OXFORDSHIRE COUNTY COUNCIL'S RESPONSE TO CONSULTATION ON THE FOLLOWING DEVELOPMENT PROPOSAL

Application no: 21/02339/REM

Proposal: Reserved Matters application for 14/02121/OUT, Phase 1 Development of 500 dwellings, landscaping, new vehicular, cycle and pedestrian access routes and other operations

Location: Proposed Himley Village North West Bicester, Middleton Stoney Road, Bicester

TITLE
**S278 OFFSITE HIGHWAY WORKS
SPINE ROAD ACCESS
GENERAL ARRANGEMENT
SHEET 1**

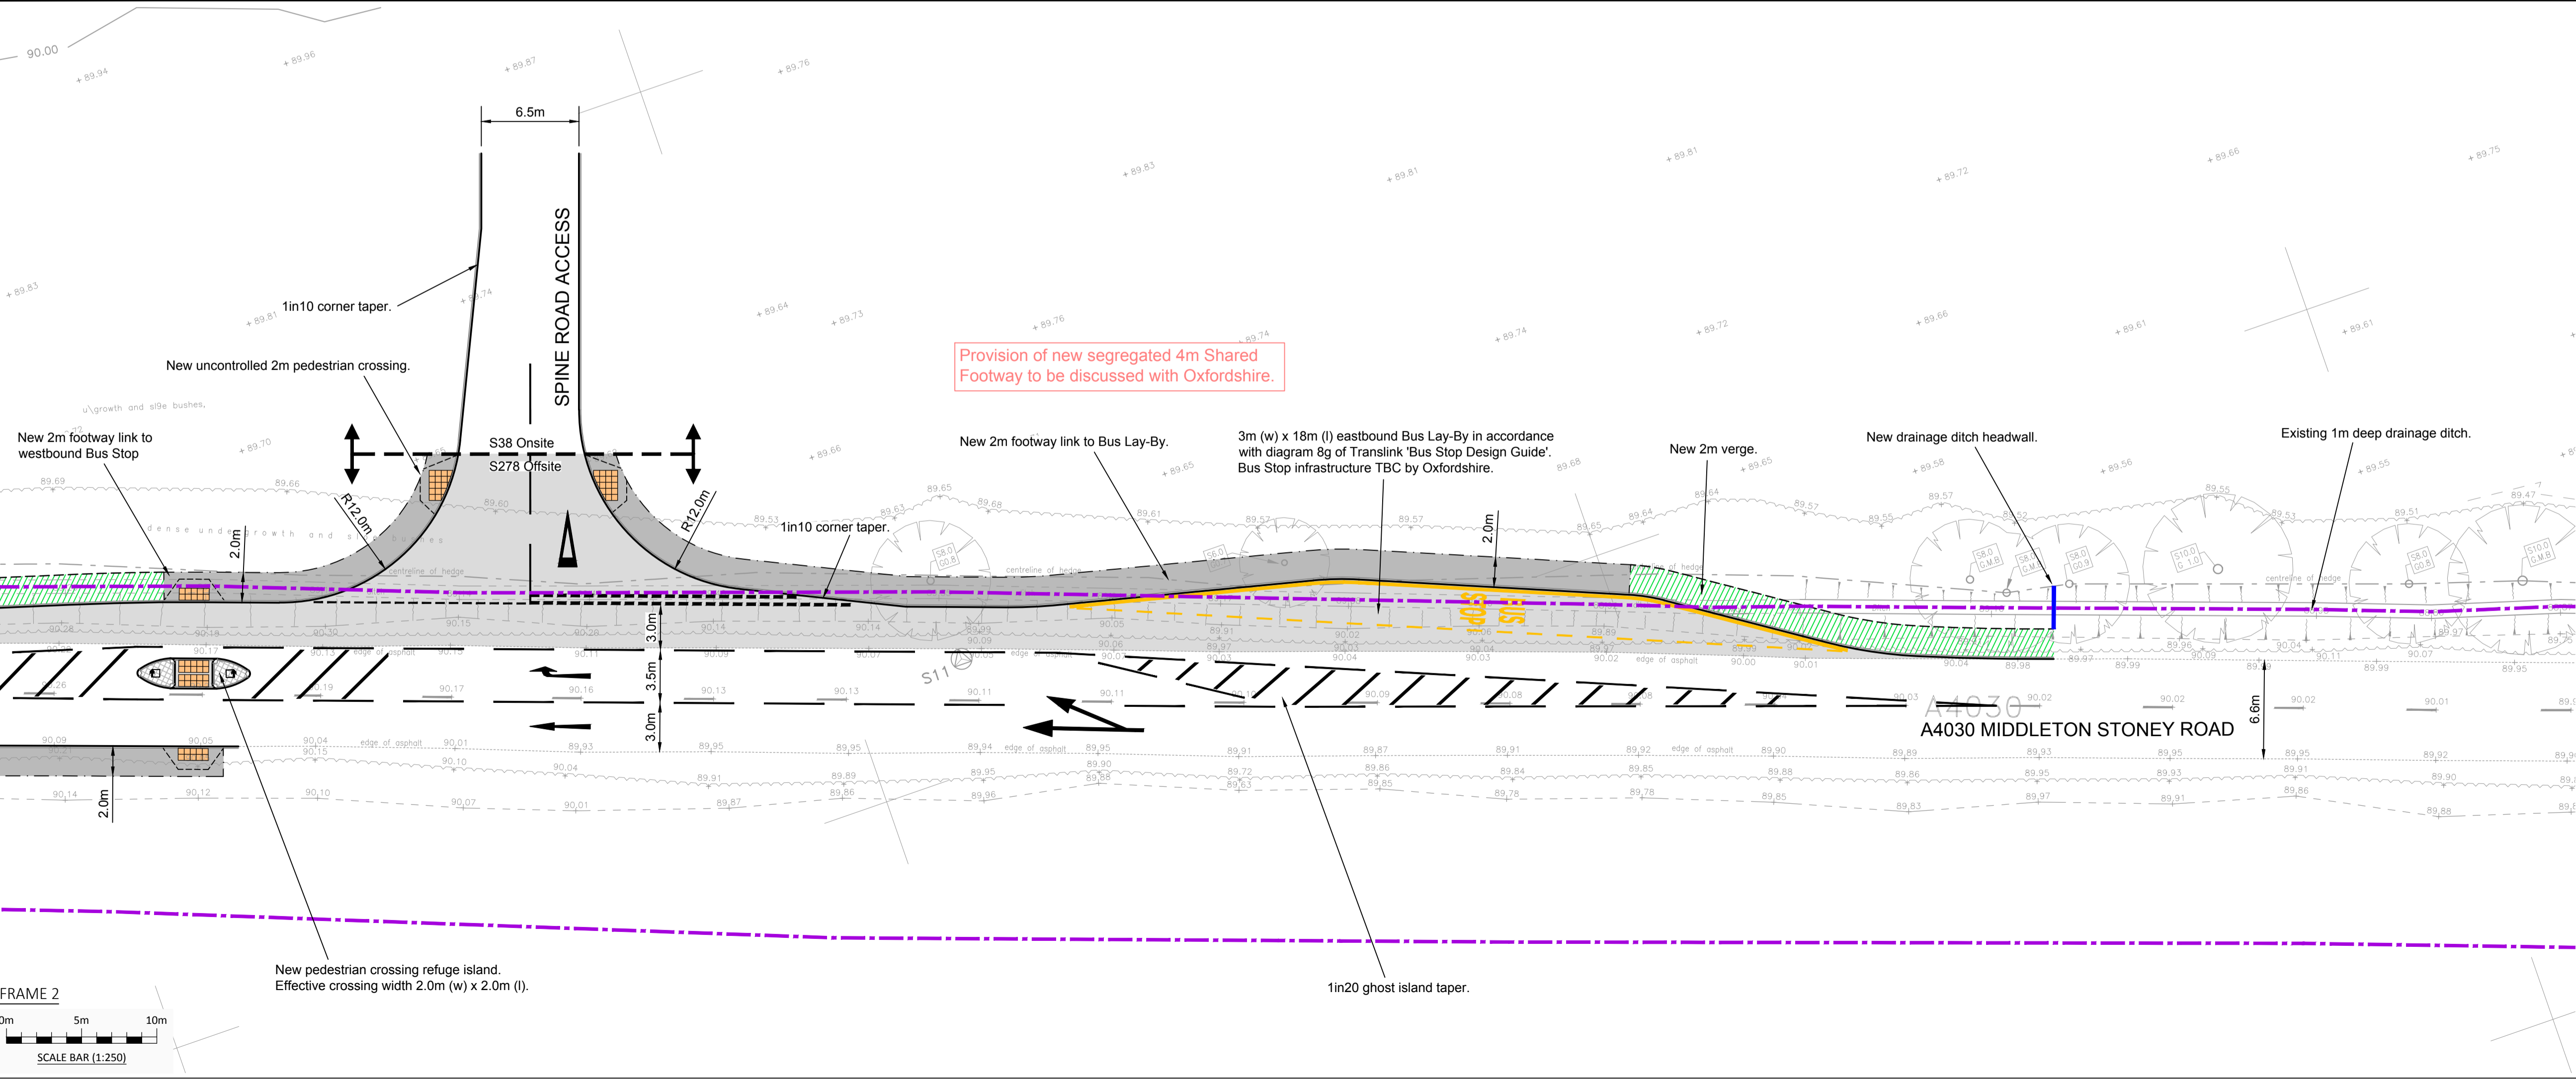
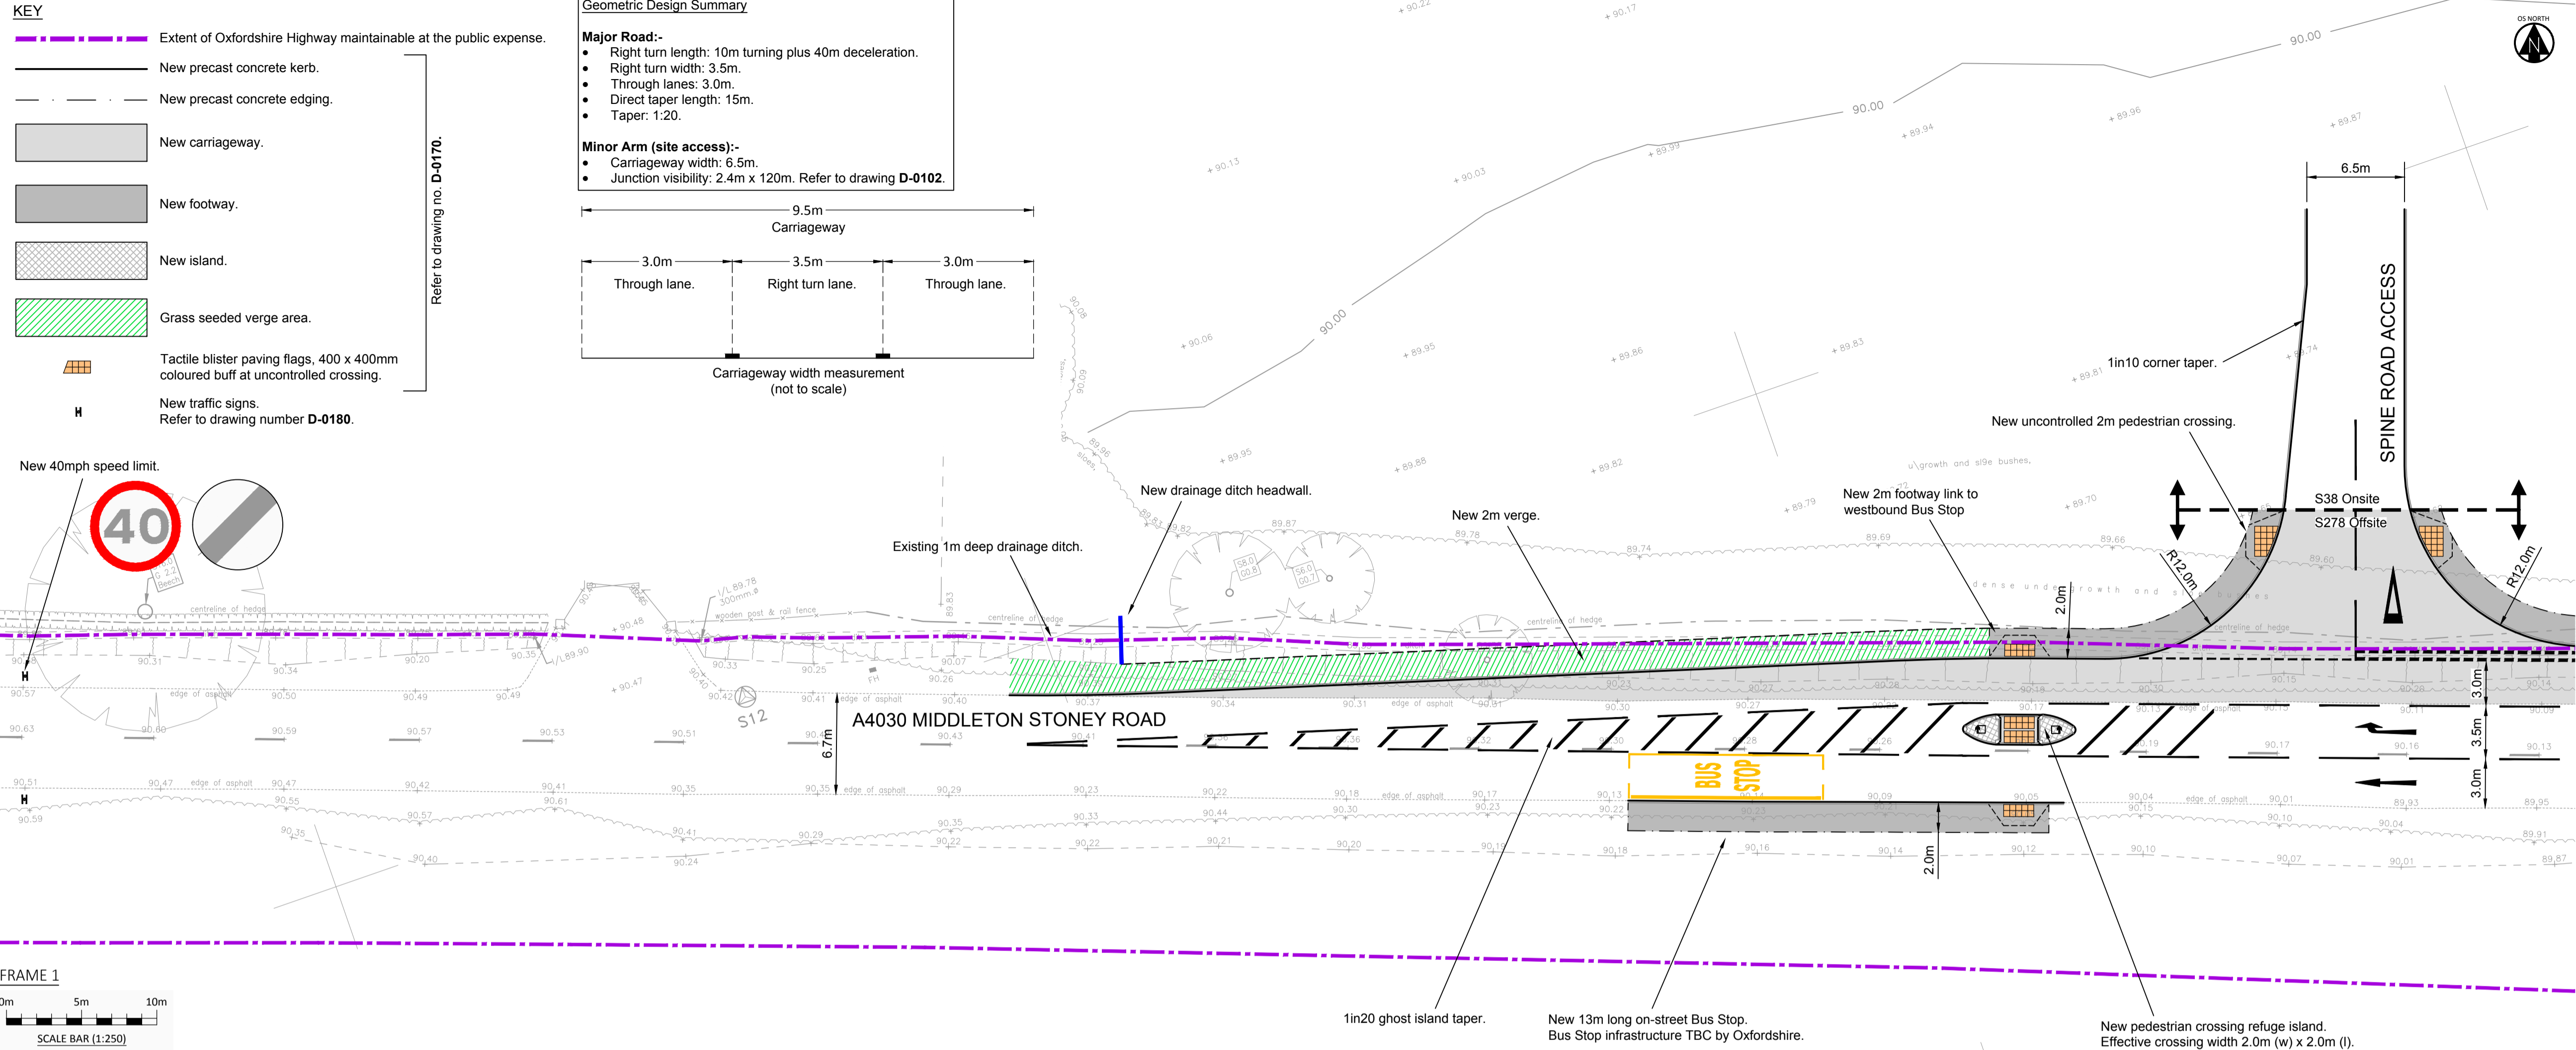
- The amended documents submitted show that the secondary access route has been widened to 6.5m which meets the bus route requirement within the Oxfordshire Street Design Guide; however, a swept path analysis should also be provided which shows buses can safely navigate around the junctions on the route without using both lanes.

The secondary access has now been widened to 6.5m to allow the streets through Phase 1 to be used as a bus route which is welcomed. In order for this to be agreed, a swept path analysis is required which shows buses can safely navigate the route with vehicles travelling in the opposite direction.

Access points to/from Middleton Stoney Road, and on-site junctions to be used by bus, must be suitable for full size single deck buses (up to 12.2m in length) to make suitable turns.
